# CITY OF PORTLAND BUILDING PERMIT

Located At 55 BOWDOIN ST

has permission to replace rear steps

Re: Revised metal railing design; 55 Bowdoin Street (Chadwick Street frontage)

2.1 SECTION THRU STAIR / ELEV. RAILINGS • SCALE: 3/4" = 1'-0"

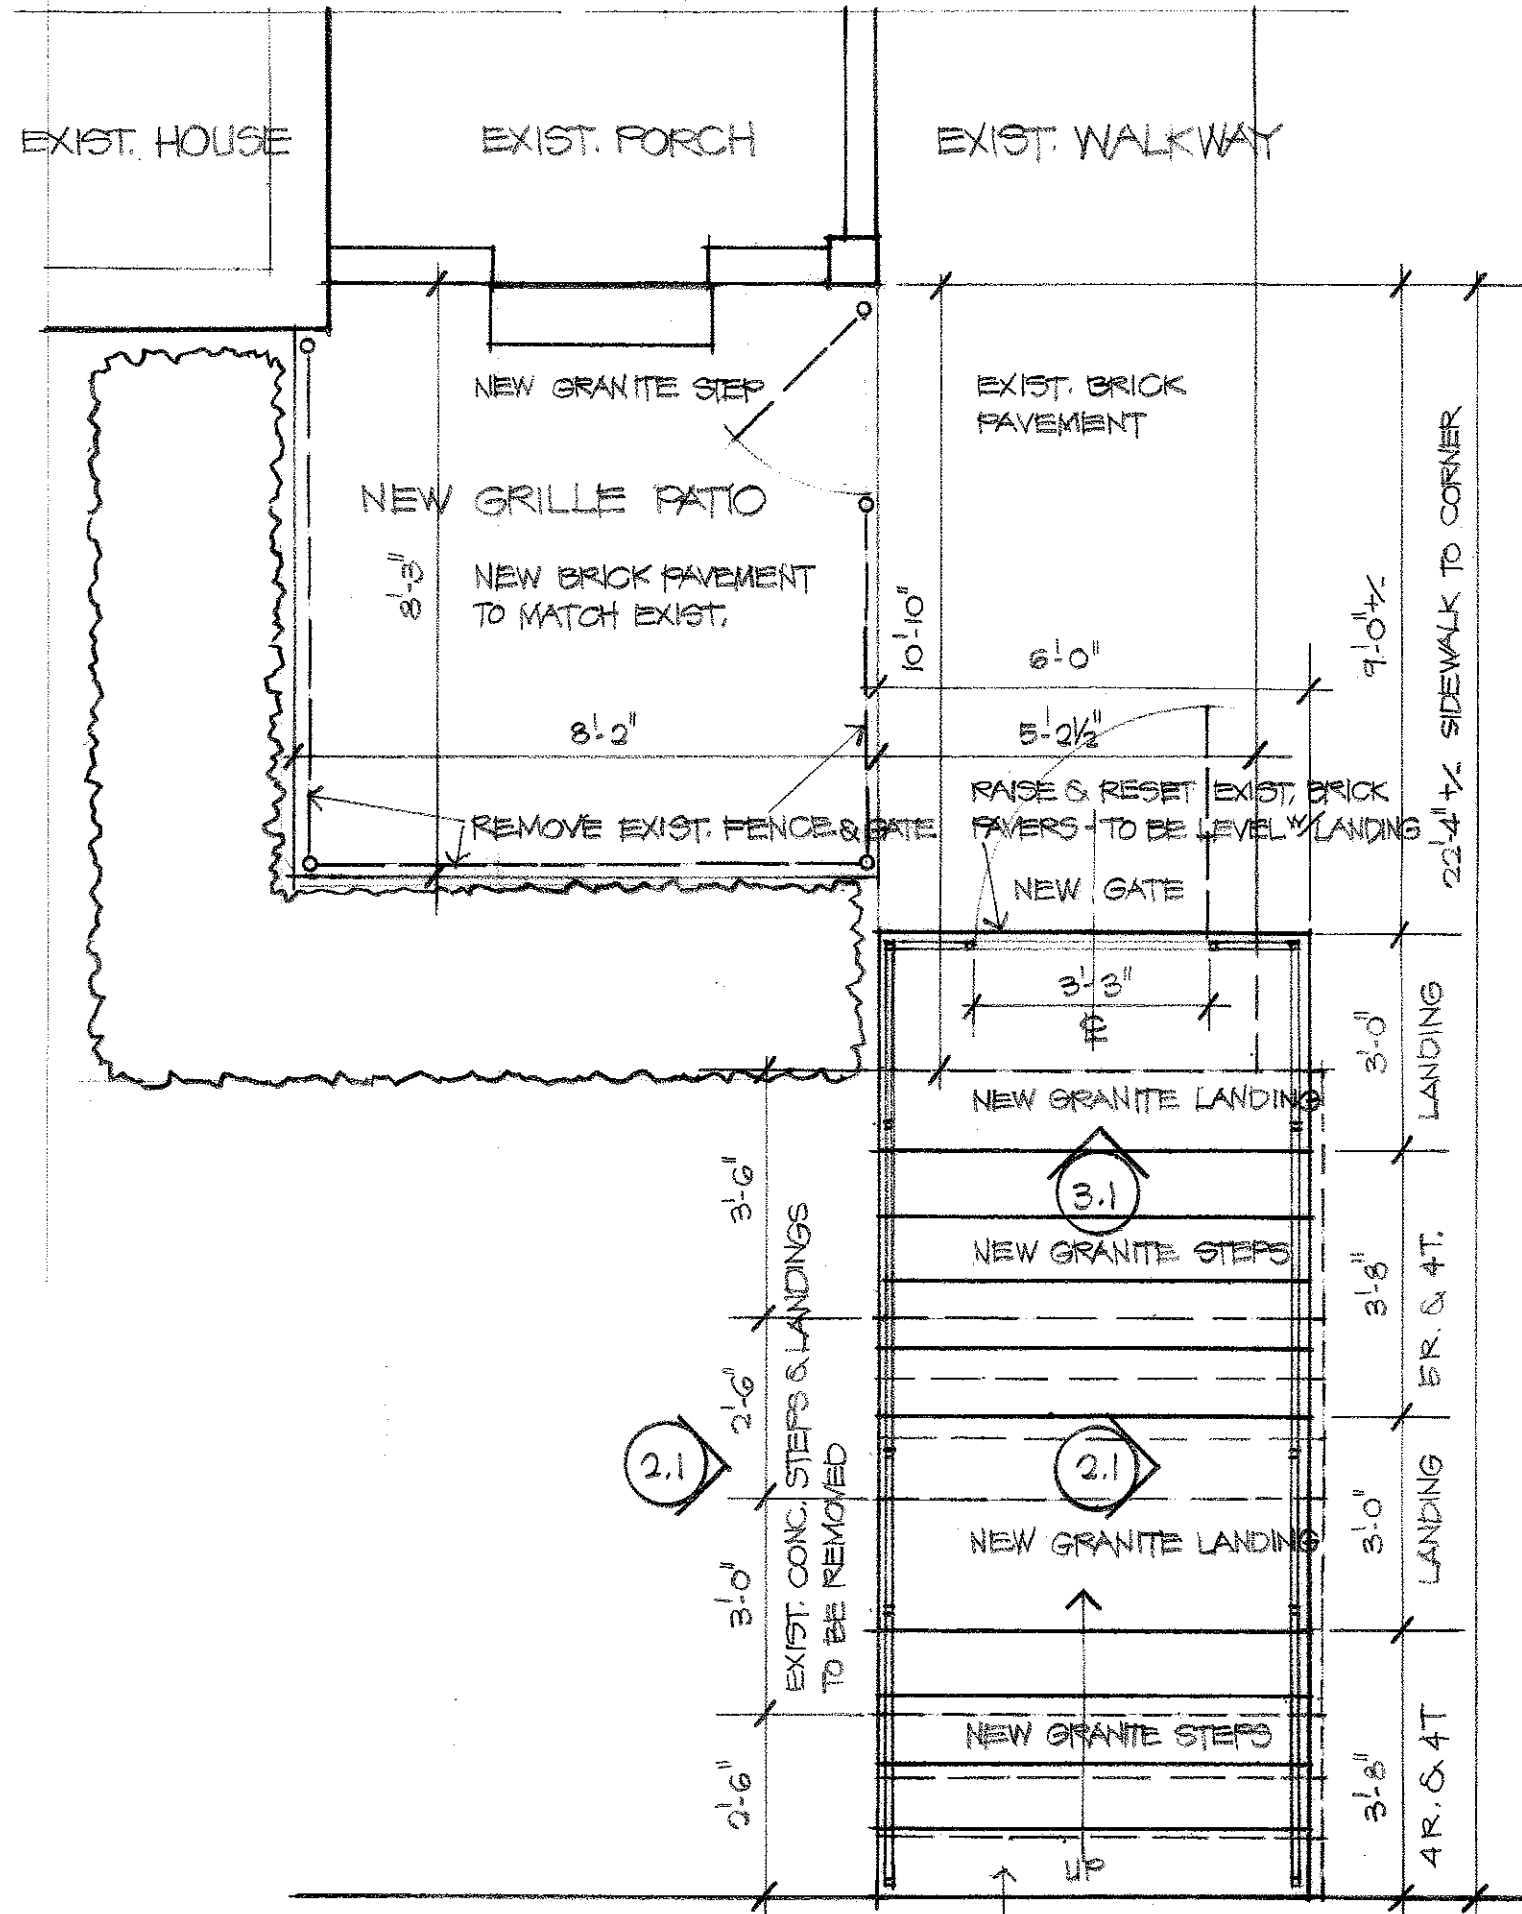
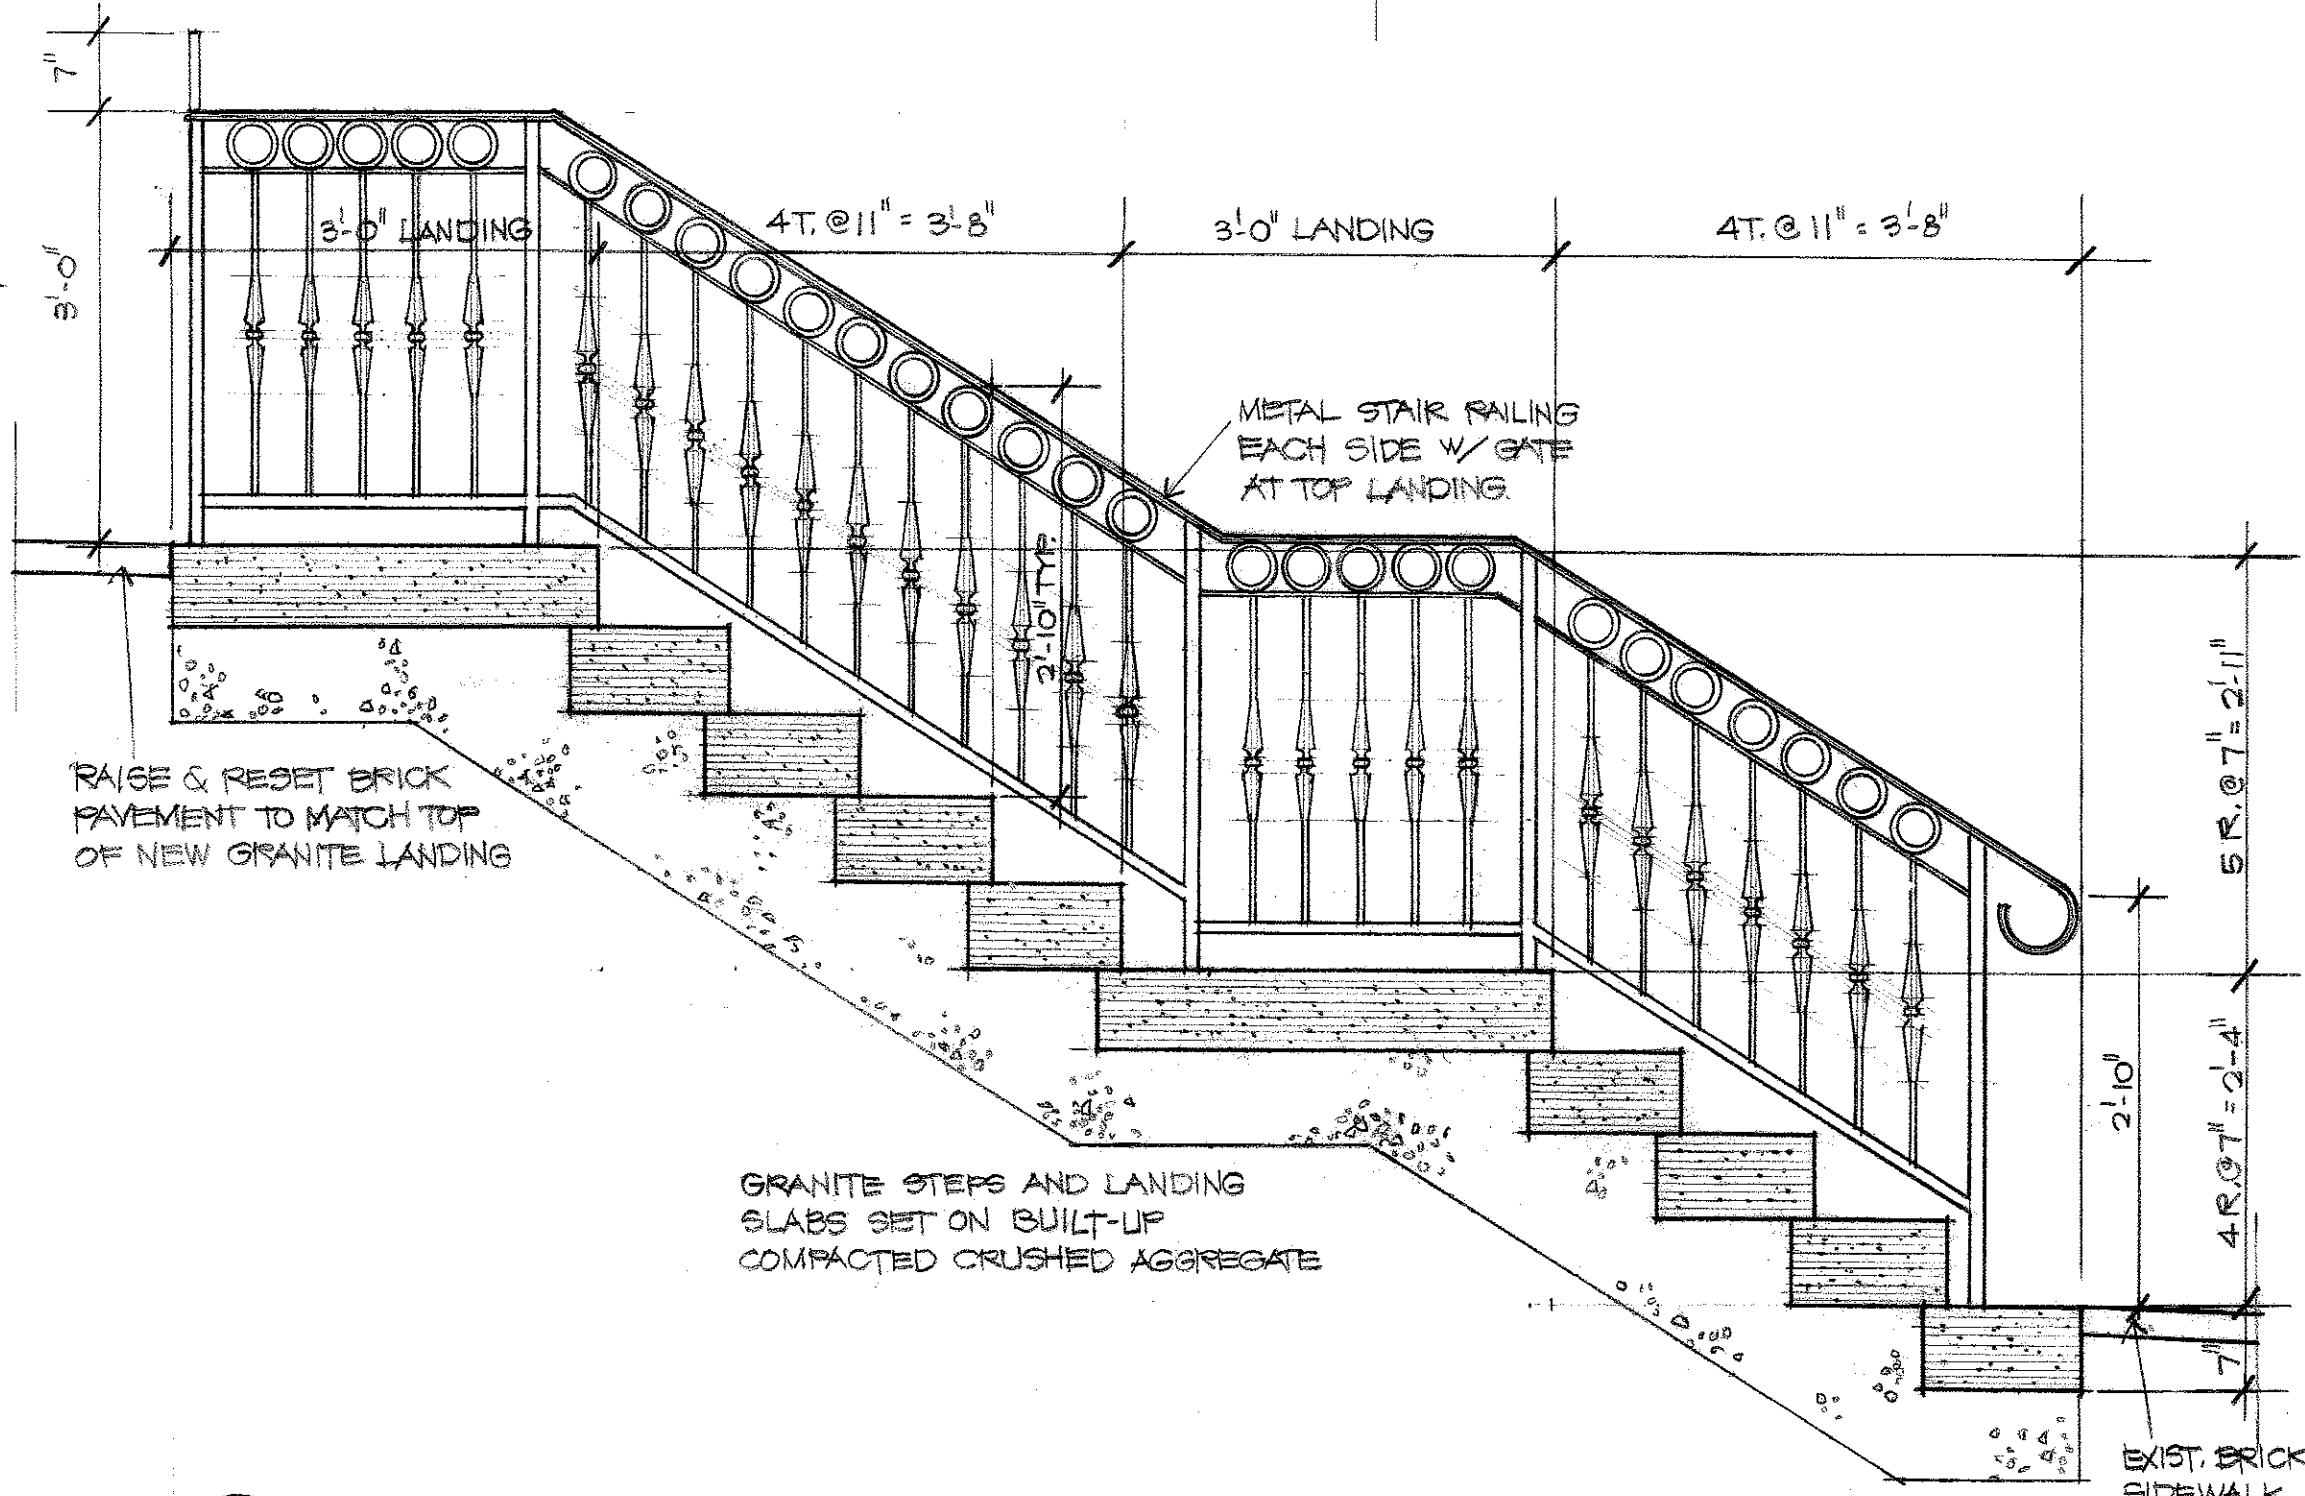
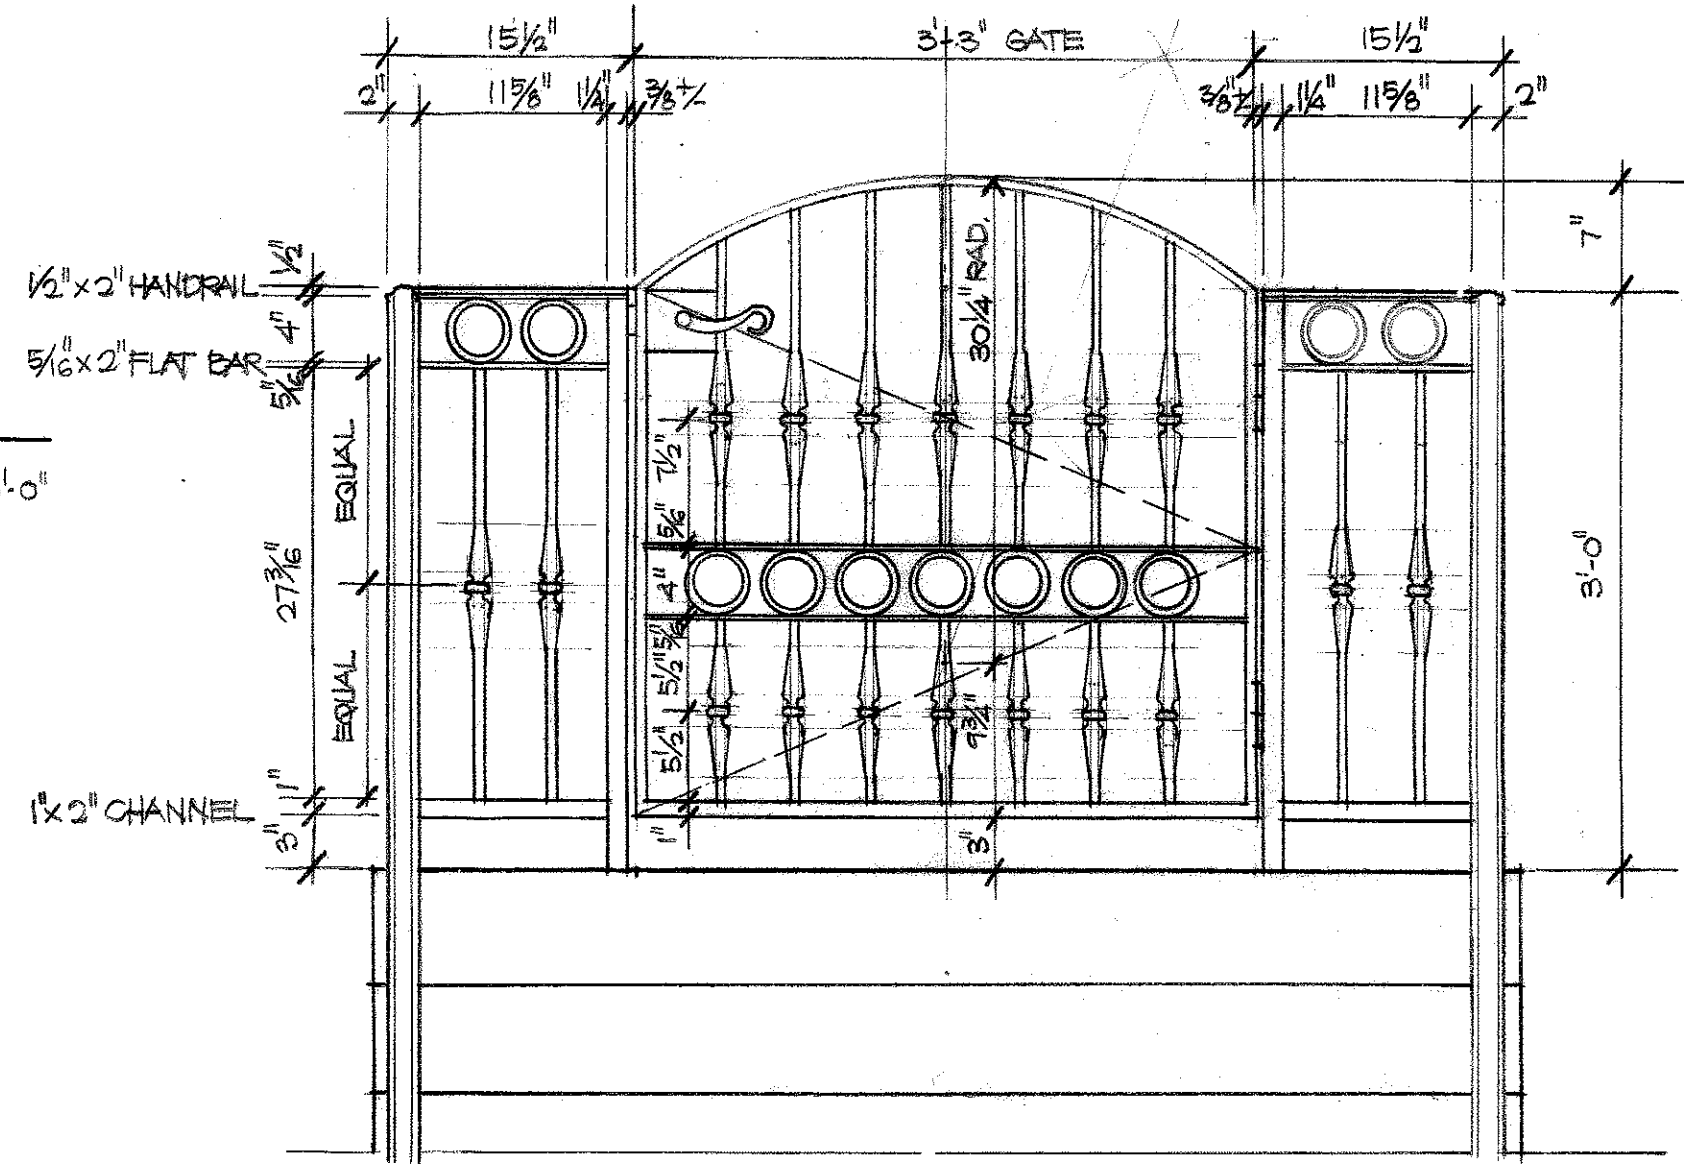
- \* The balusters are to be simple square balusters, not turned balusters as shown in the submitted drawing. This condition is based on the recommendation of HP Board members, who were consulted regarding the revised design proposal. Board members were unanimous in their view that the railing design should be further simplified in order to be compatible with other traditional railings treatments in the neighborhood.

\* As per 10/25/11 decision letter from Historic Preservation Program Manager, the balusters are to be simple square balusters, not turned balusters as shown in the submitted drawing.
